Our Ref: A/148/19/T
Your Ref:

Town & Country Planning Act 1990 (as amended)
Town & Country Planning (Tree Preservation) (England) Regulations 2012
Application for Works to Tree(s) on trees subject to a Tree Preservation Order (TPO)

Development Reduce height and prune sides by up to 3m to 3 No. Beech trees, Prune to shape up to 2m 1 No. Ornamental Cherry tree, Crown reduction by 1.5m 2 No. Deodora Cedars

Location The Firs Roundstone Lane Angmering

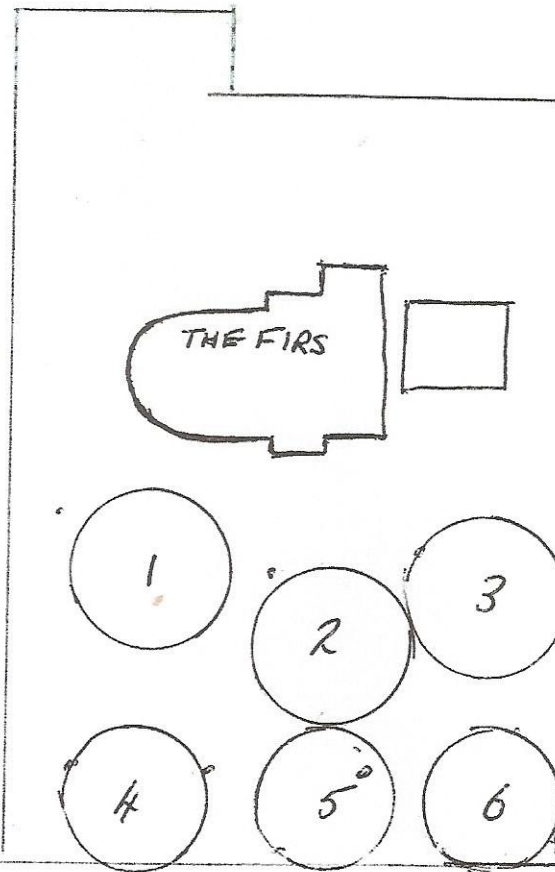
Please confirm if the proposed work to 1 No. Ornamental Cherry tree is a Crown reduction up to 2m.

The plan you have provided does not include road names. Please provide a sketch plan that includes road names and adjoining properties, and shows the location of the trees.
